# CITY OF ALBUQUERQUE

**Re: Winrock Redevelopment Section 4 – 2100 Louisiana Blvd.  
Grading and Drainage Plan, Engineer's Stamp Date 7-20-15  
Drainage file number (J19D058C)  
Engineer's Certified Plan , Stamped 8-5-2016**

Based on the Certification received 8-8-16, the site is acceptable for a TEMPORARY 60 - day Certificate of Occupancy by Hydrology, with the following conditions/comments:

A1 FIRST FLUSH & STORM DRAIN LAYOUT
SCALE: 1"=100'

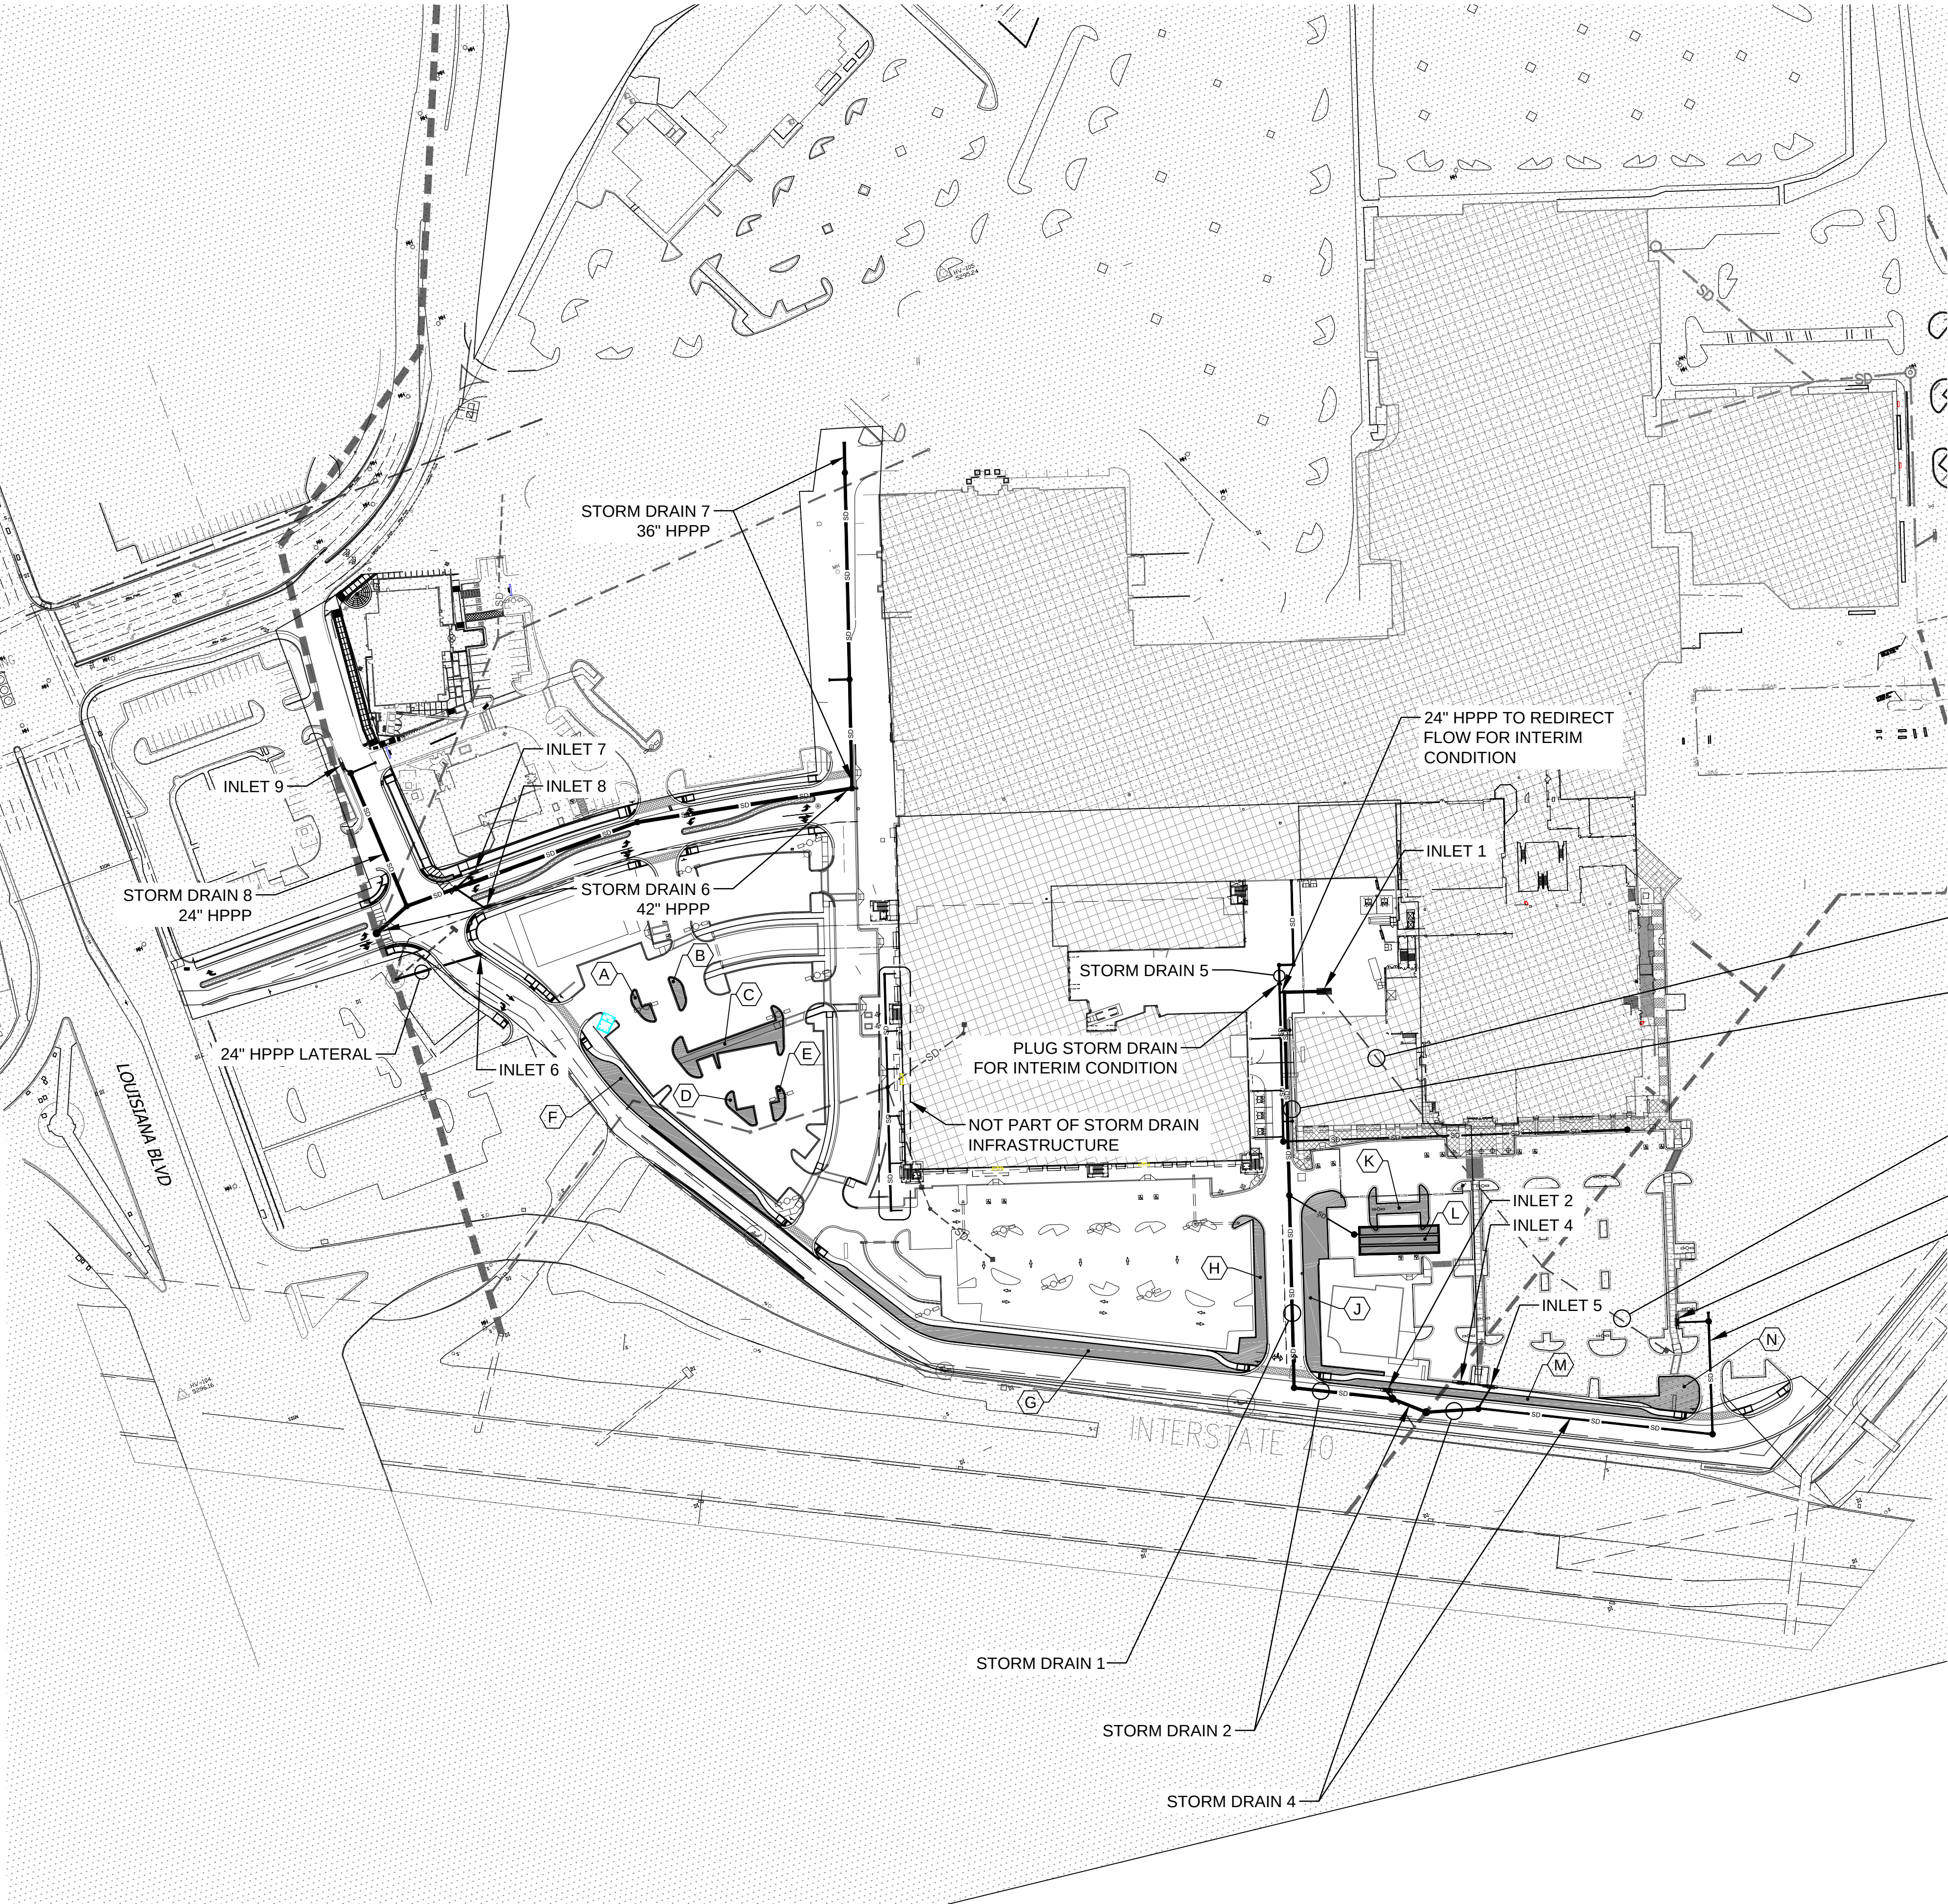
- The Engineer's Certified Plan should also include the Storm Drain sheets showing Storm Drain and inlets in the Final condition.
- There is an existing inlet and Storm Drain that was left in place that should be noted.
- It is unclear if the Storm Drain parallel to and north of the underground retention system was built or not.
- Since Building Permit approval was contingent on corrections in the Work Order Construction Set, Final C.O. will only be issued after acceptance of the Work Order.
